From: Amanda Scholes on behalf of Planning.Responses
Sent: 16 October 2019 08:34
To: Planning Scanning
Subject: FW: Planning Consultation on: R/230/19/PL

Engineers Comments Regarding Surface Water Drainage

Registered: 10th October
2019
Site Address: Springfield House Springfield Close Rustington BN16 2SZ
Grid Reference: 506286 102083
Description of Works: 1 No. dwelling with detached garage (part resubmission following R/91/17/PL & R/204/18/PL).

Job Title	Springfield House		
Client	Castle Property Developments		
Drawing Name	Garage - Plan & Elevations		
Drawing Status	Planning		
Drawn by	DF	Date	Sept 19
Checked by		Date	
Drawing Scale	1:50 & 1:100 at A1		
Drawing No	Status	Revision	
181303/	09

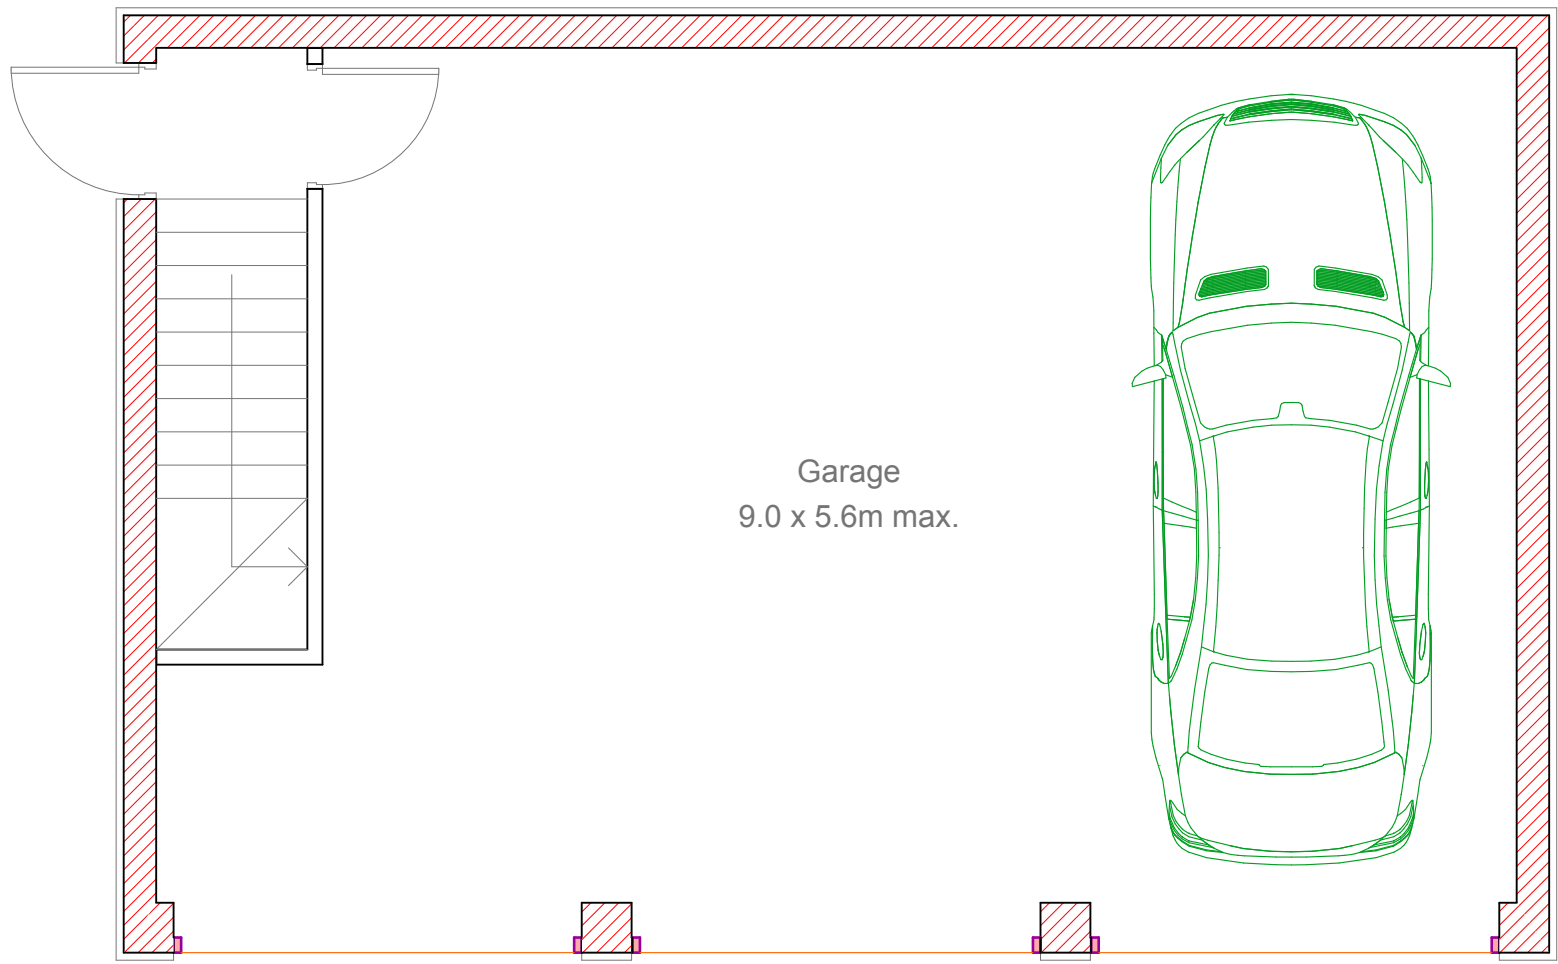
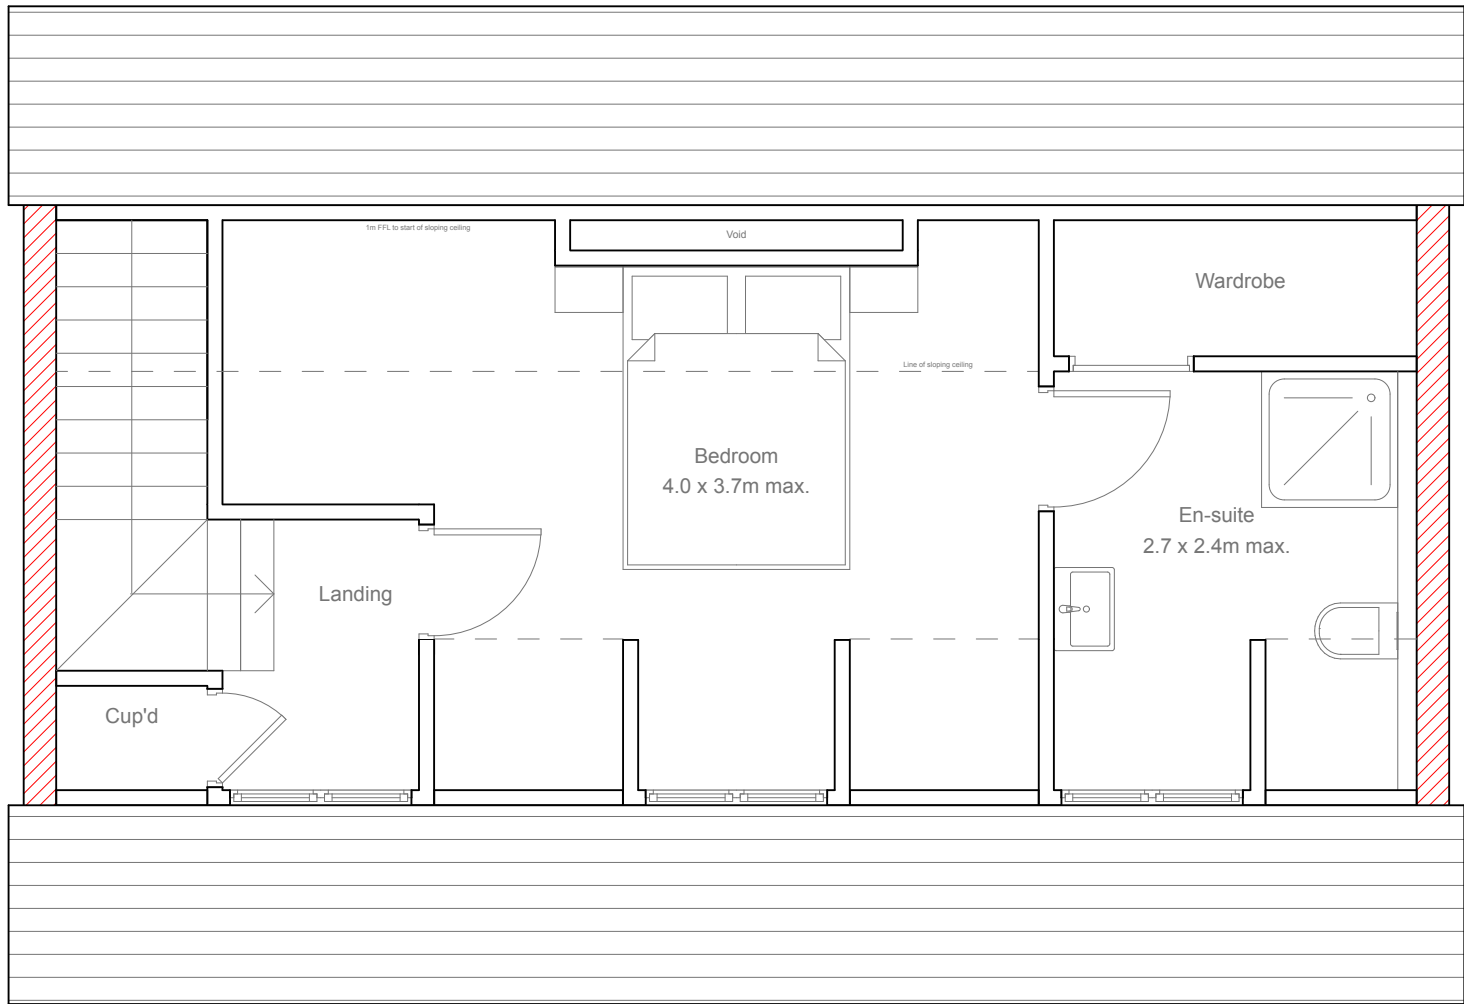
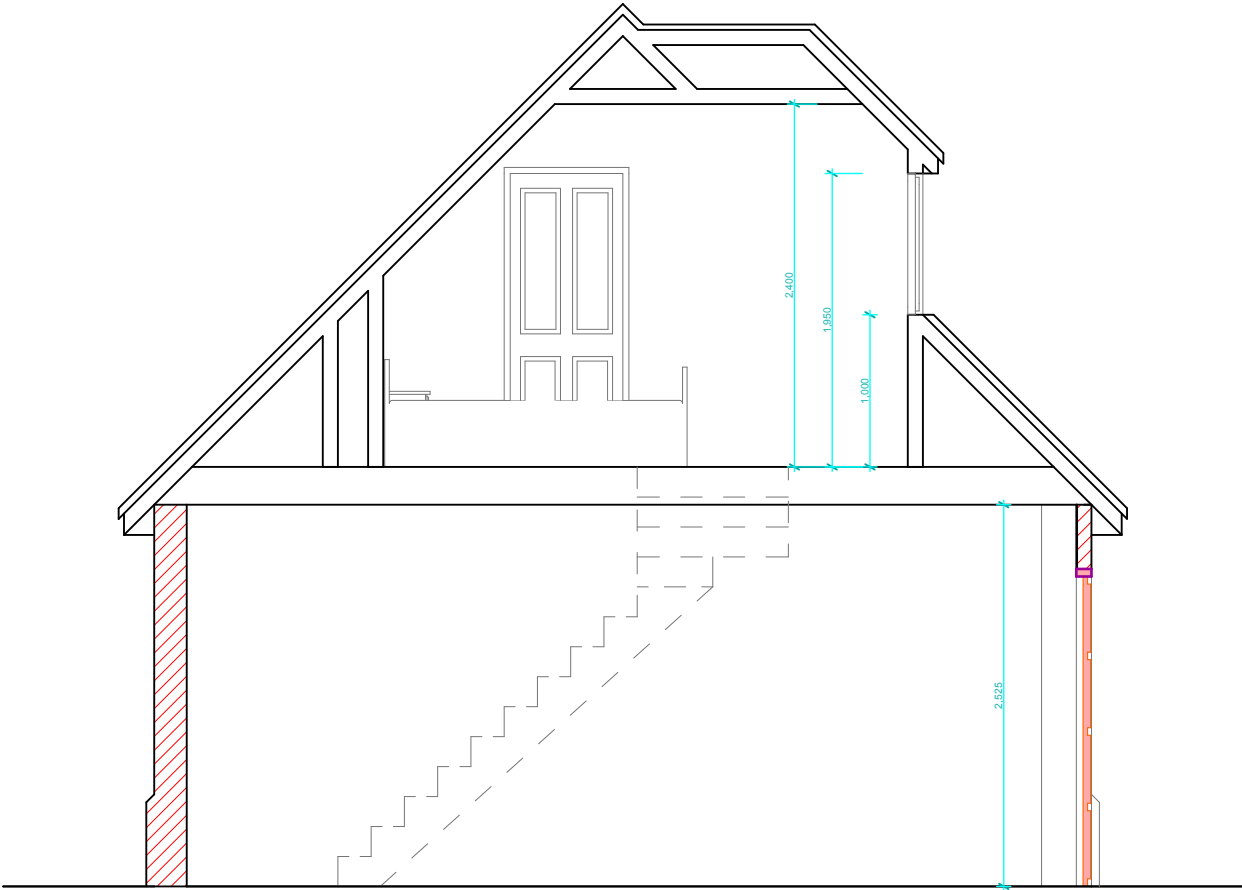
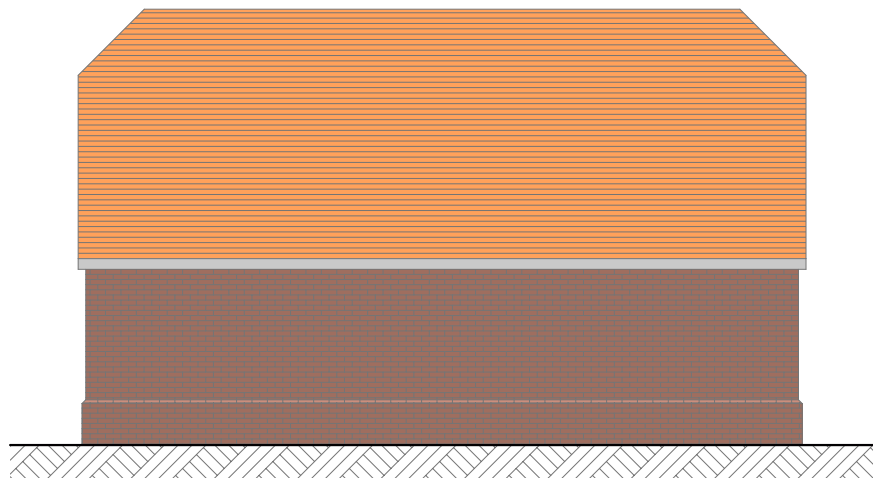
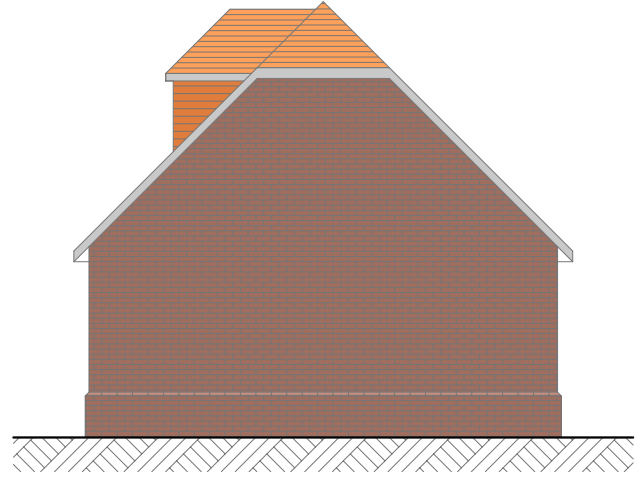
1. The location of the pool is different on the Drainage Layout to the Site Plan, Location and Block Plans. It is not shown at all on the Foul Drainage Drawing.
2. It is assumed that the pool is open and not covered. If it is covered then it will need to be accounted for in the Surface Water Drainage Design.
3. No information is given for how the pool will overflow and backwash. It is assumed that this will go to the foul sewer but this is not shown on the Foul Drainage Drawing. Southern Water will need to be consulted if this is the case. The foul drawing also shows the formally approved 2 bay garage which this application removes. The proposed 3 bay garage is not shown.

Client Castle Property Developments					
Project Land at The Spires, Springfield Close					
-	Original	PTC	RTFC	8.1.20	
Rev.	Description	App.	Chk.	Drn.	Date

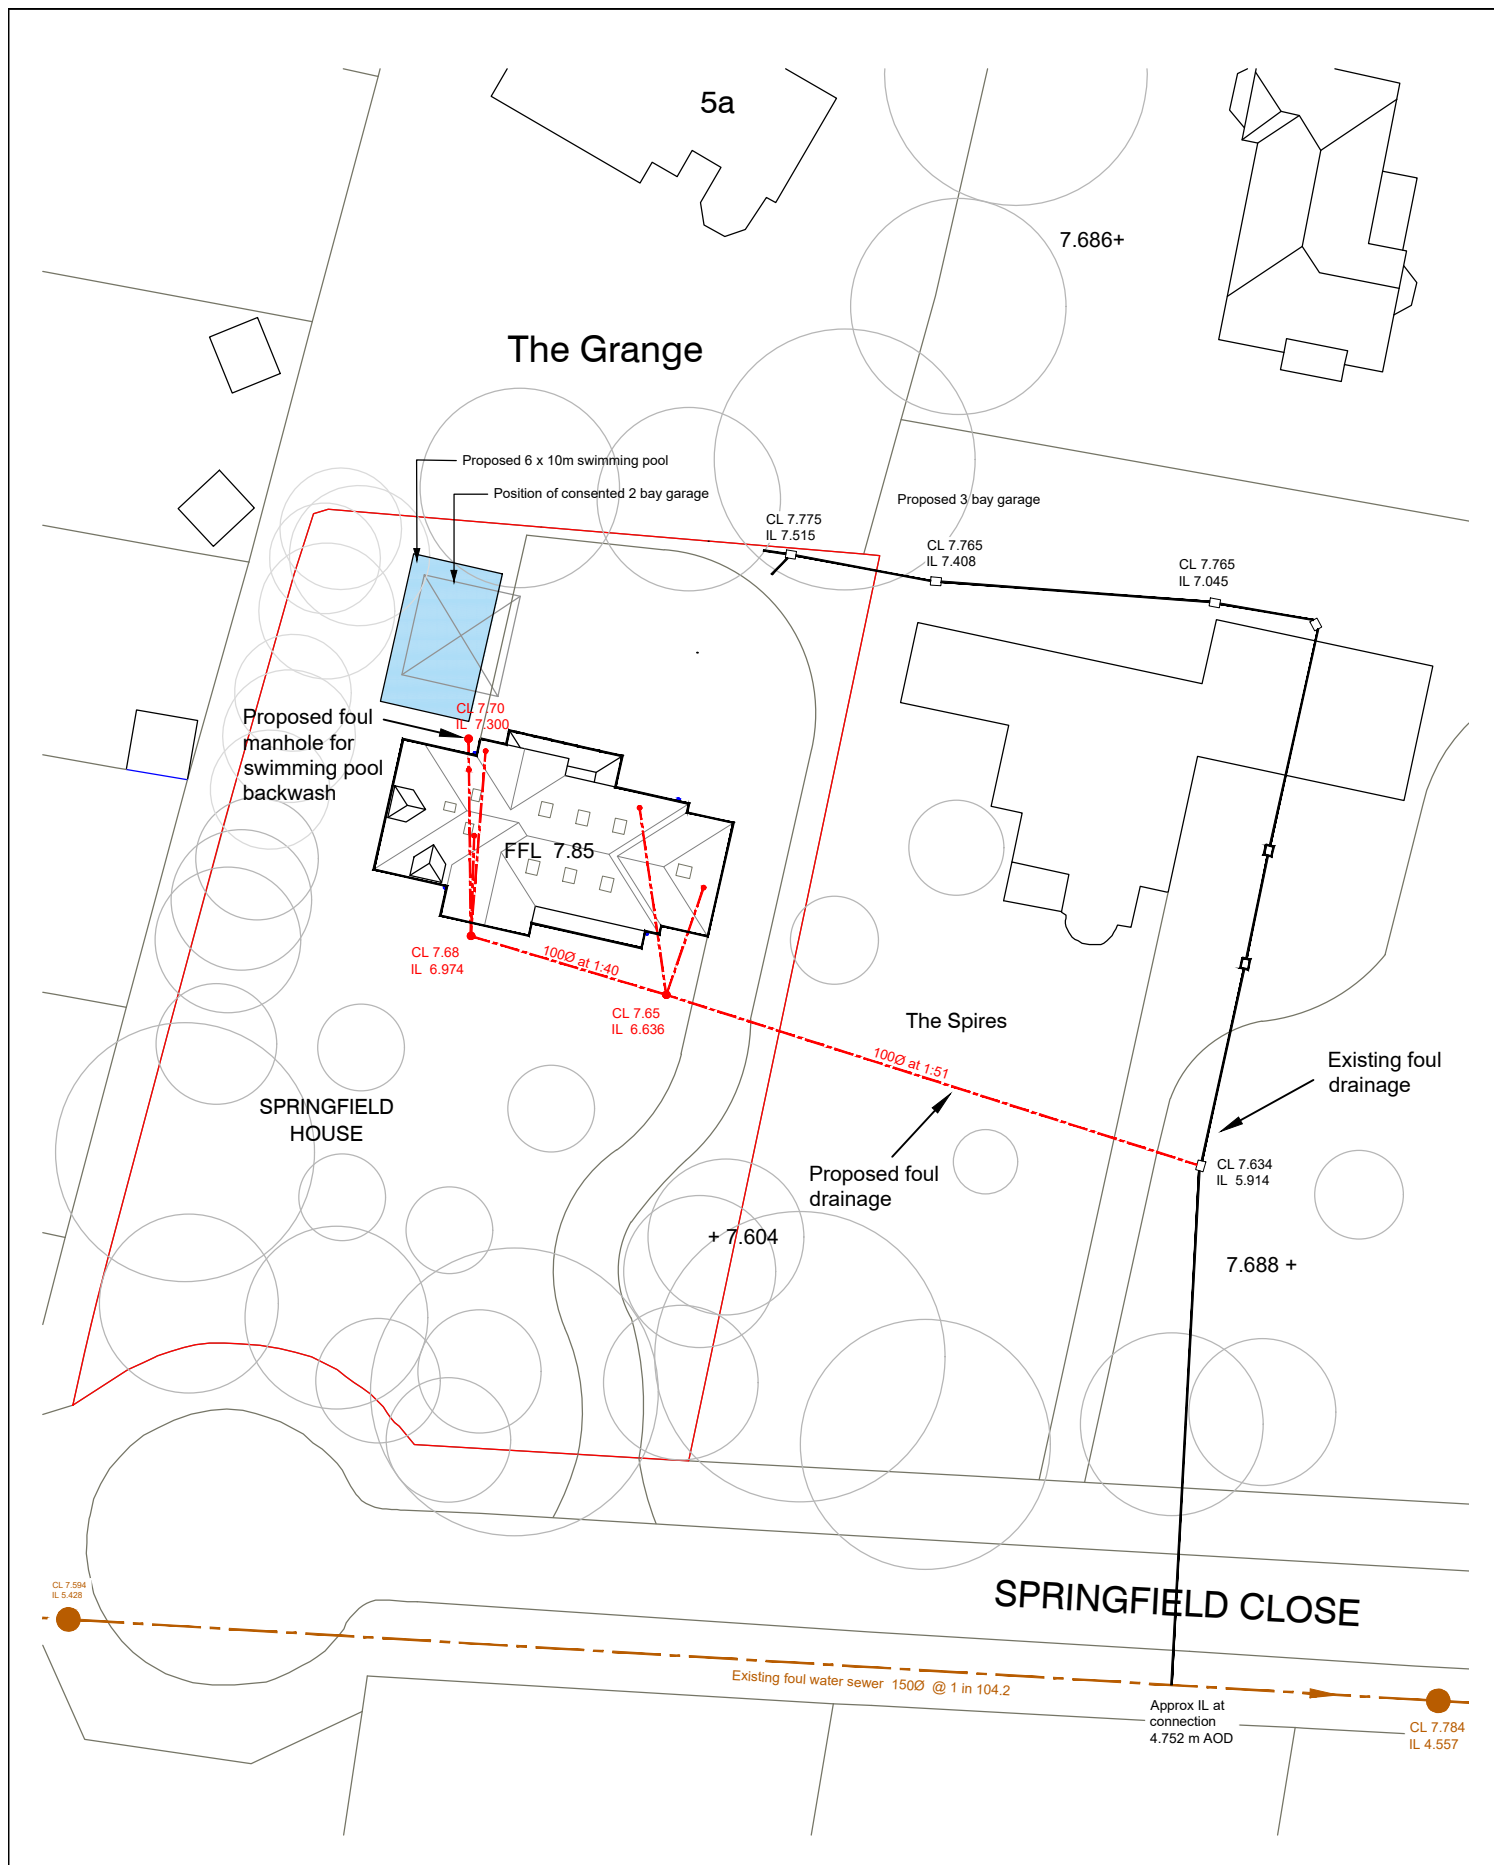
1. The specification of the soakaways is unchanged from the previous application R/204/18/PL. However as the increase in impermeable surface area is small and given the location of the site, it is considered appropriate to only request that the drainage design be conditioned to be constructed as detailed in the surface water drainage proposals supplied.
